JD/HG3317

**MONCKTON ENERGY LIMITED – PLANNING APPLICATION (YOUR REFERENCE 2016/1169)
FOR A GAS PEAKING SCHEME AT THE MONCKTON COKE AND CHEMICAL WORKS, NEAR
ROYSTON, BARNLSLEY, SOUTH YORKSHIRE**

Site Layout

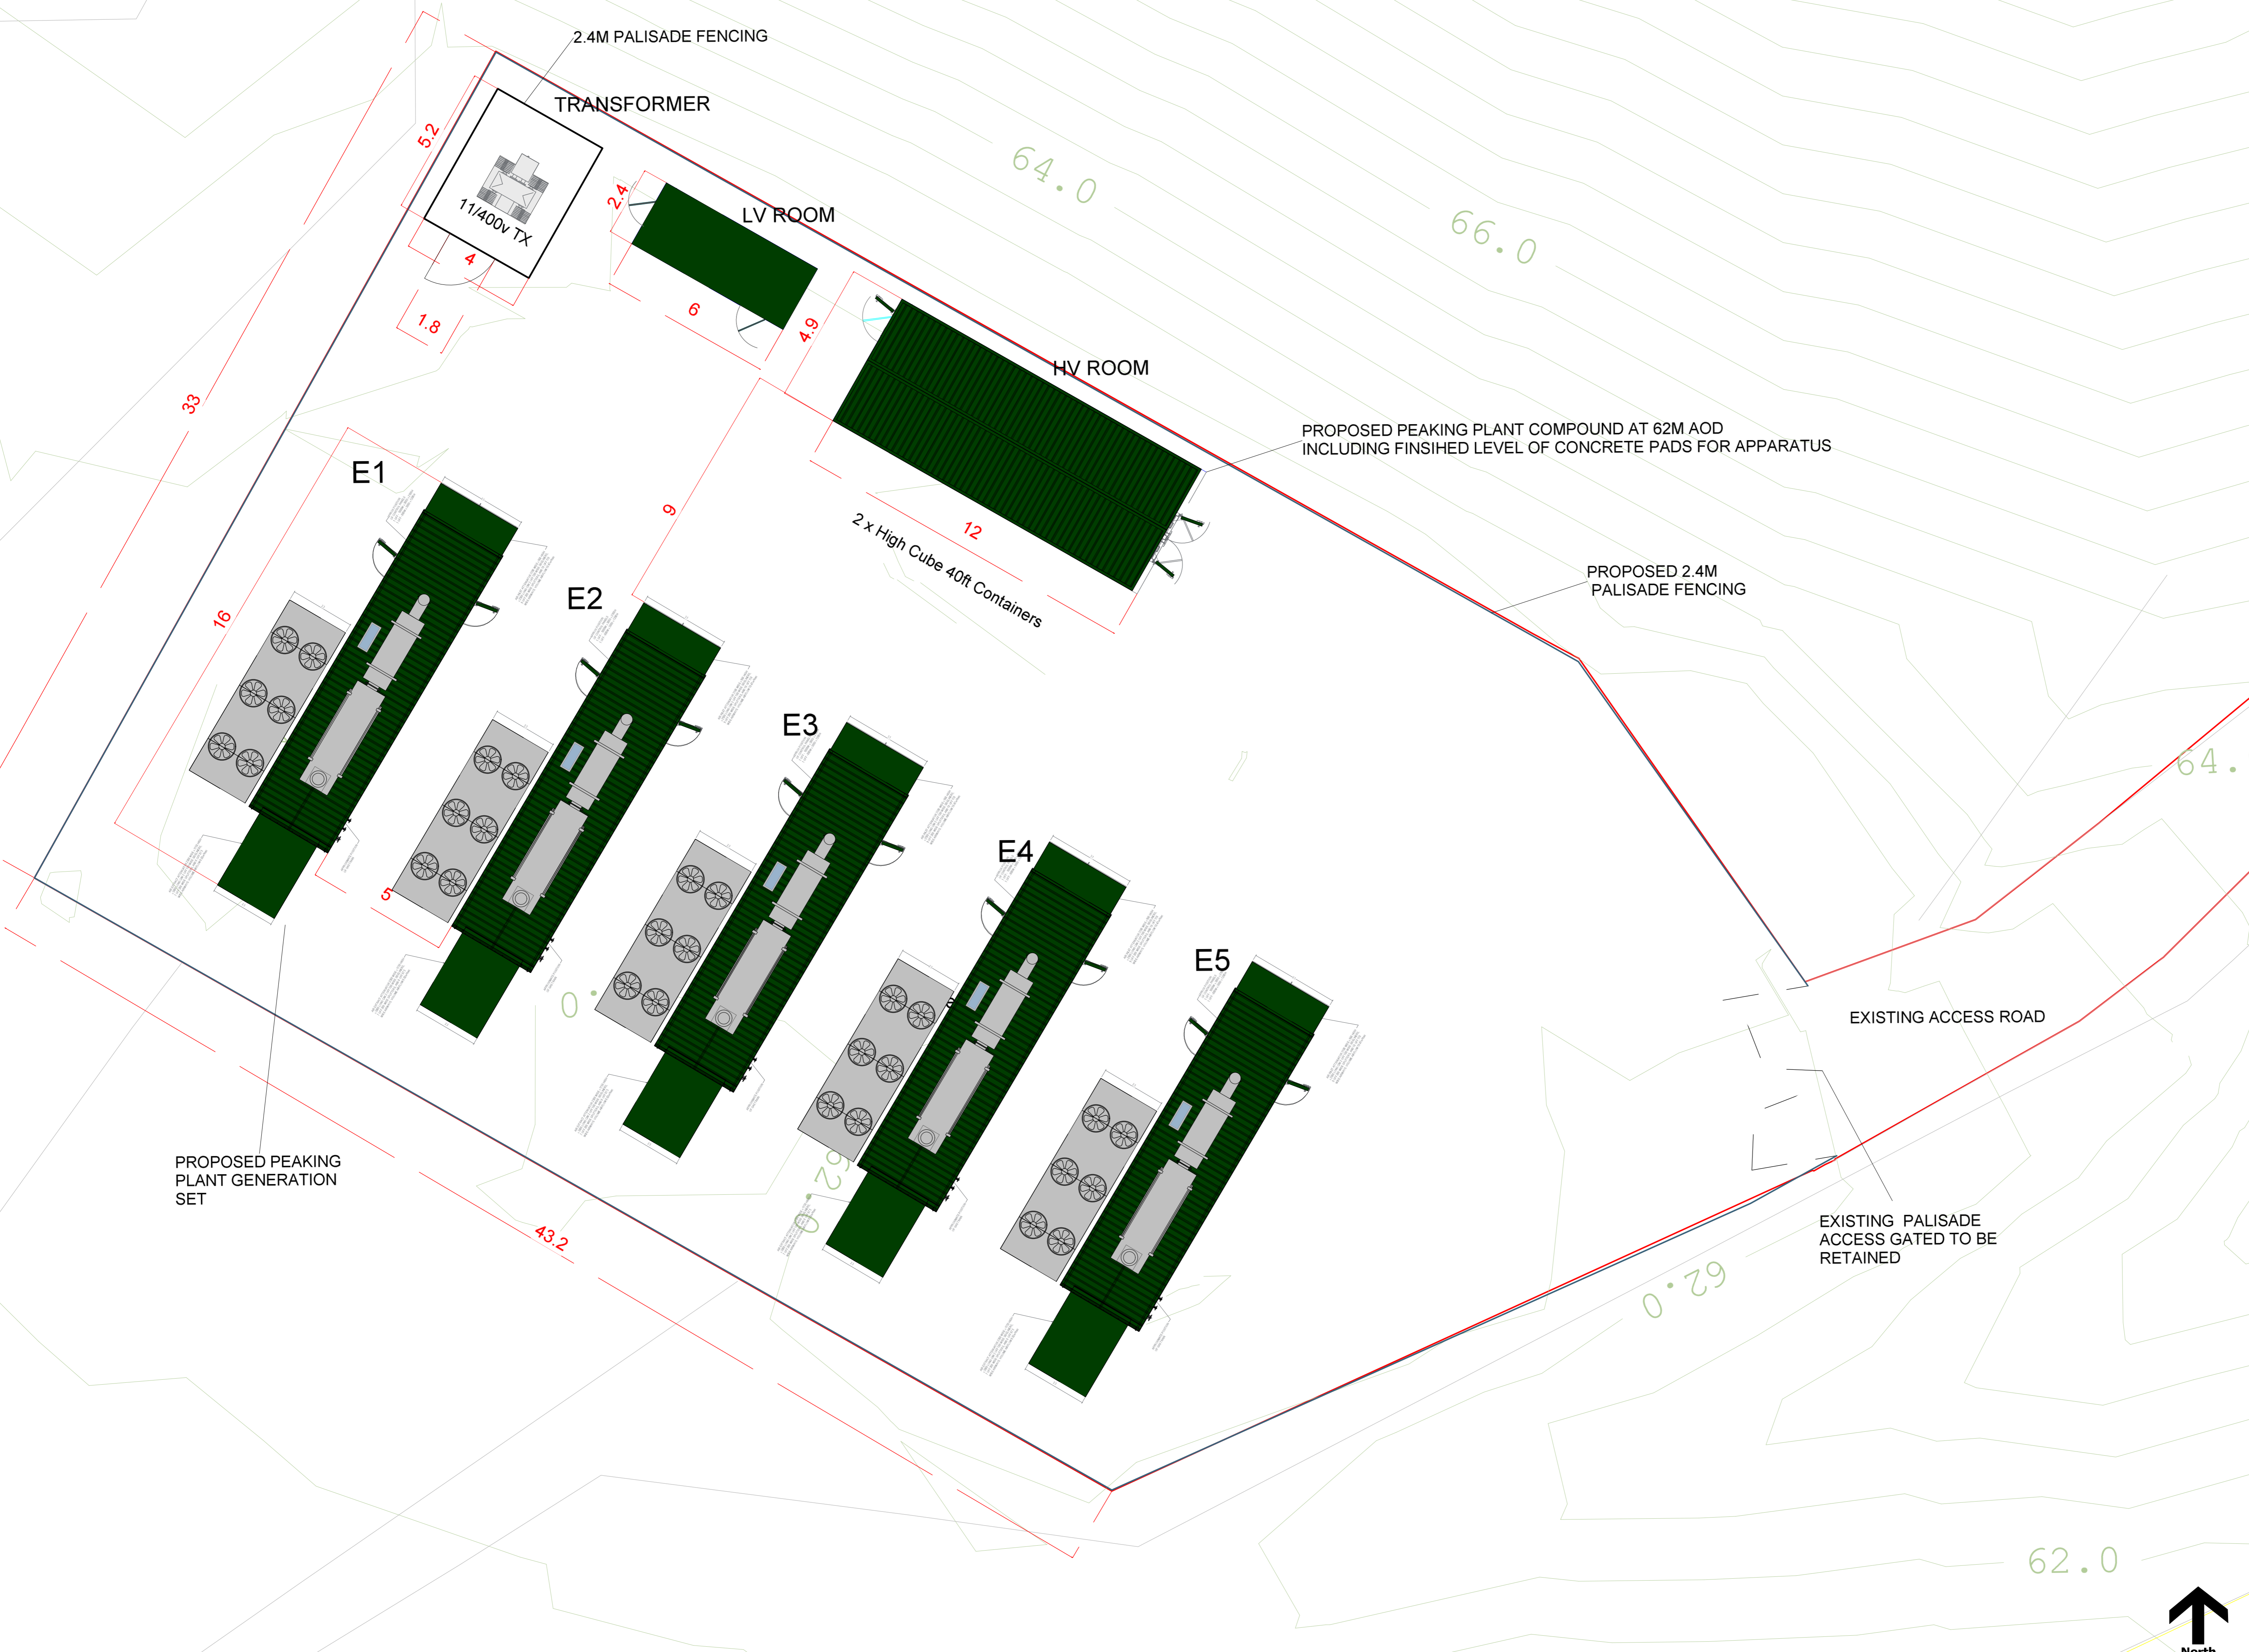
In this respect, the scheme now involves an amended site layout with four engines for the generation of up to 7 megawatts (MW) (rather than five engines previously to generate up to 10MW), which are located towards the west side of the site compound, then two transformers, LV and HV rooms and a portable office would be located to the east side of the compound. In this respect, please find attached Site Layout Drawing No. SP-01 Rev. C and the Peaking Plant Plan and Elevation Detail as shown on Drawing No. 02 Rev. A. The other drawings for the Scheme that were submitted to yourselves previously, which included plan and elevation detail for the LV and HV rooms, and portable office, along with the site palisade and acoustic fencing remain unaltered.
